GREY HOUSE PRECINCT,  
PYMBLE LADIES' COLLEGE

SSD-17424905

Architectural Design Report  
Addendum

05. 04. 22

SHADOW DIAGRAMS -
SHEET 3

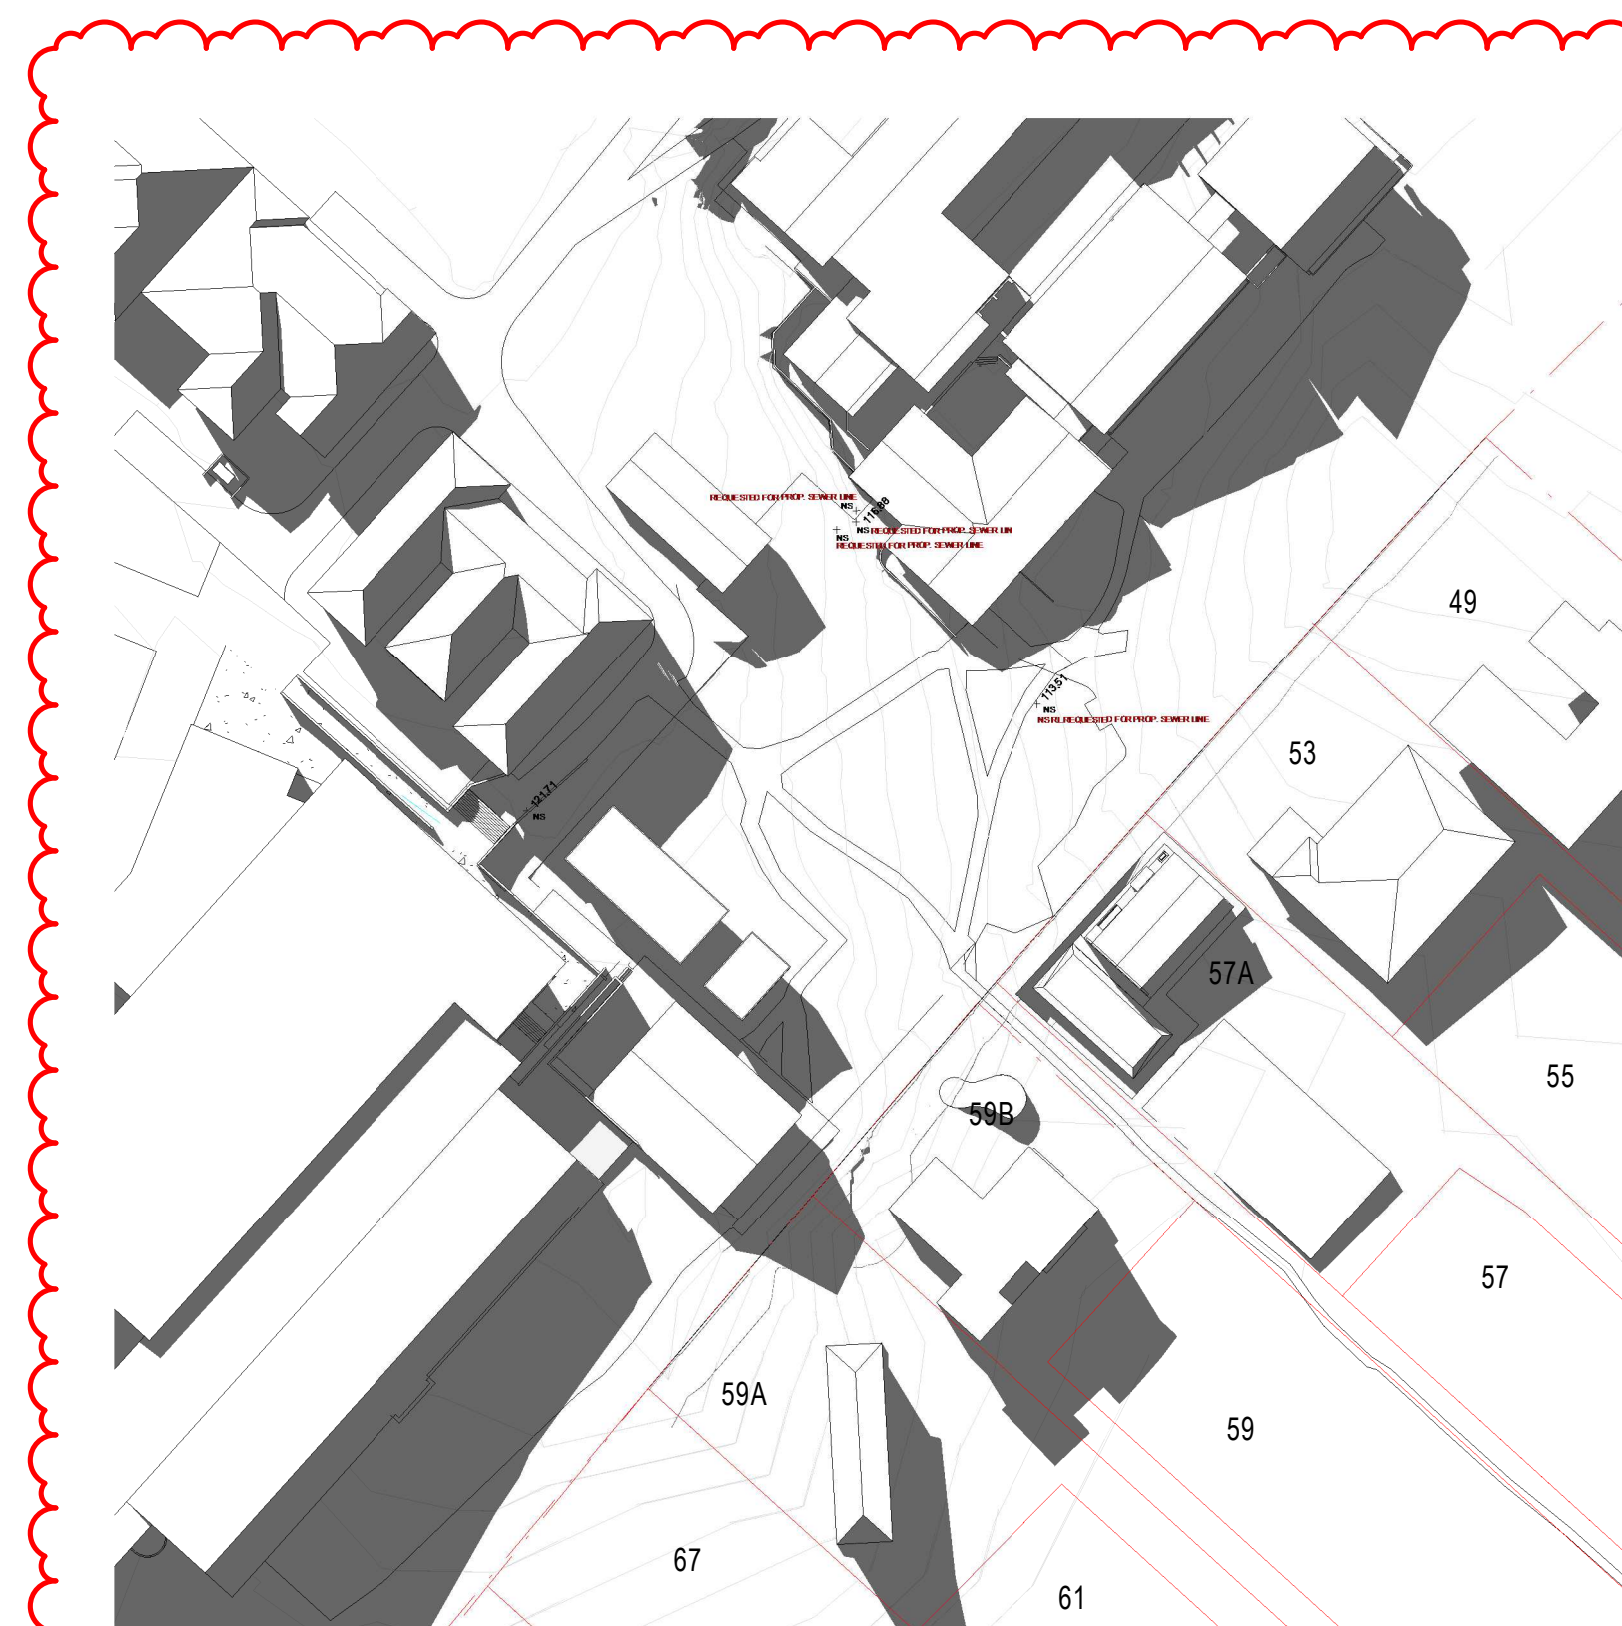
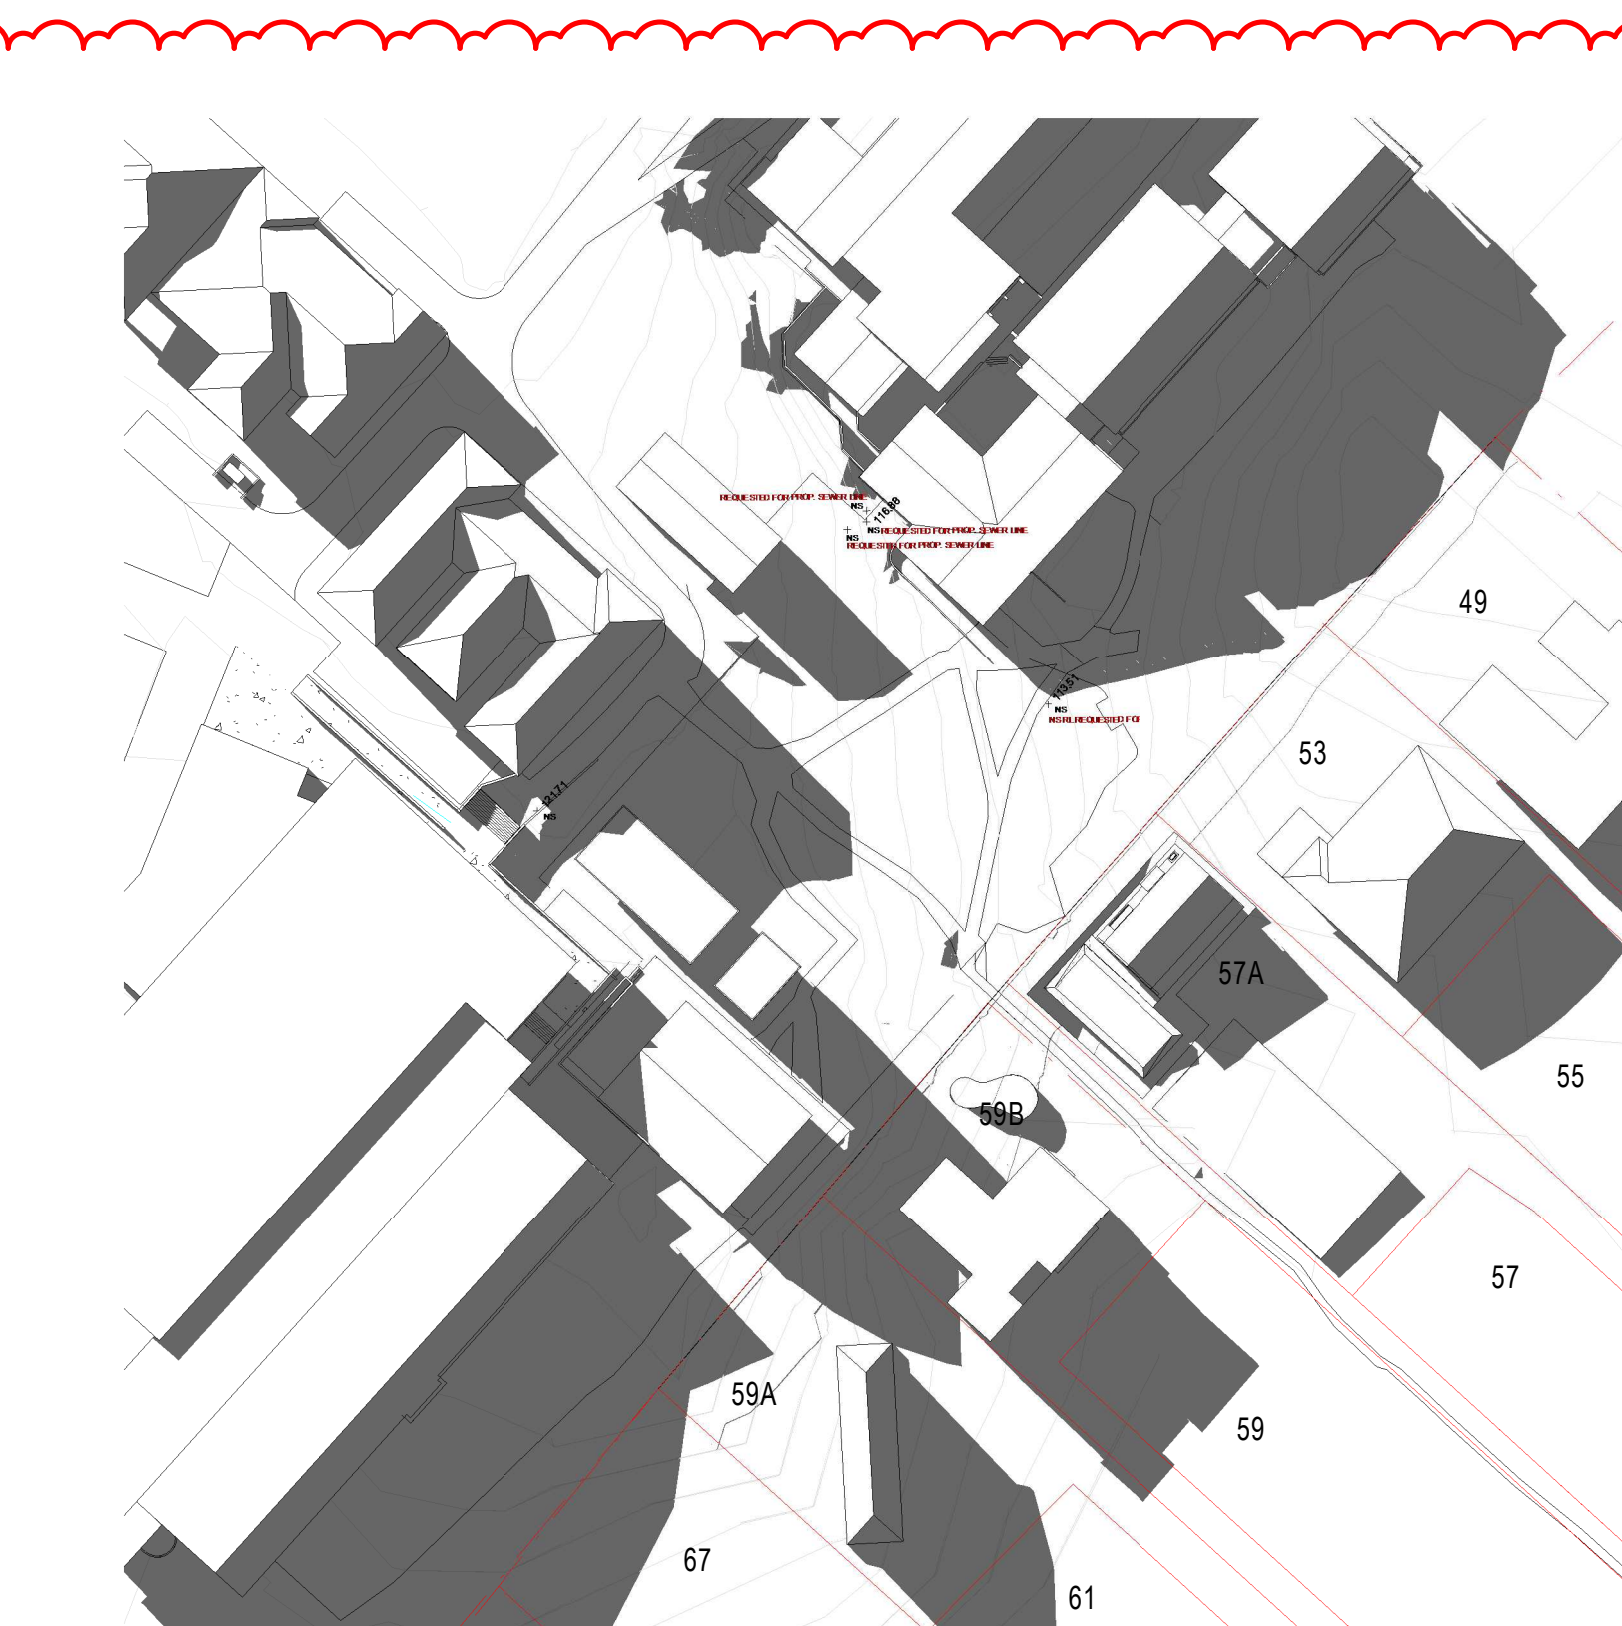
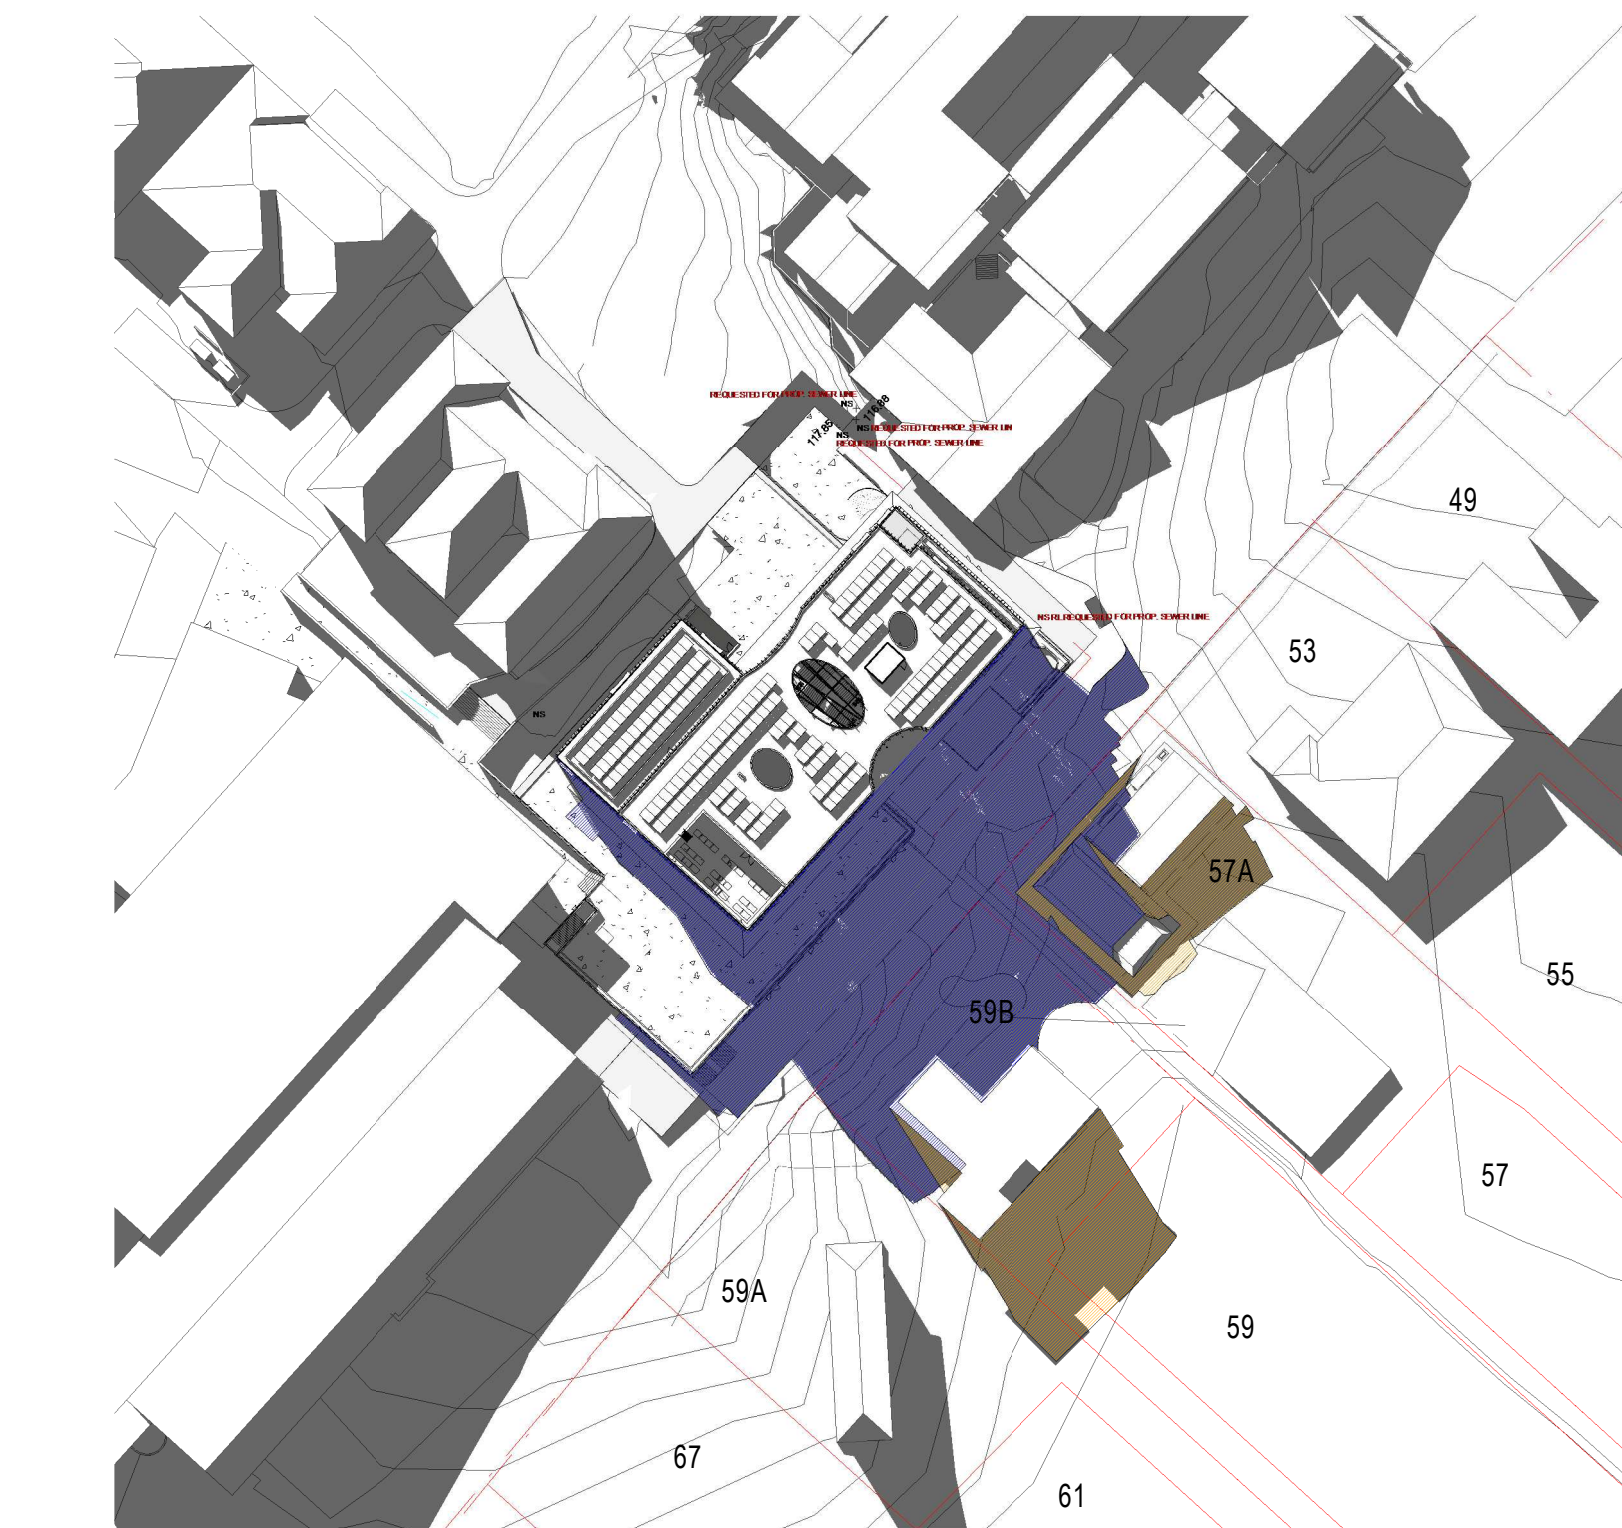
11. Clarify the impact of the proposal on the solar access of the adjoining properties, as this has not been clearly demonstrated. Provide existing and proposed diagrams identifying the quantum of solar access to the living area glazing and the principal private open space of affected properties to demonstrate if a reasonable level of solar access will be maintained for the adjoining properties.

This report includes solar access analysis of the impact of the Grey House Precinct to the adjoining residential properties.
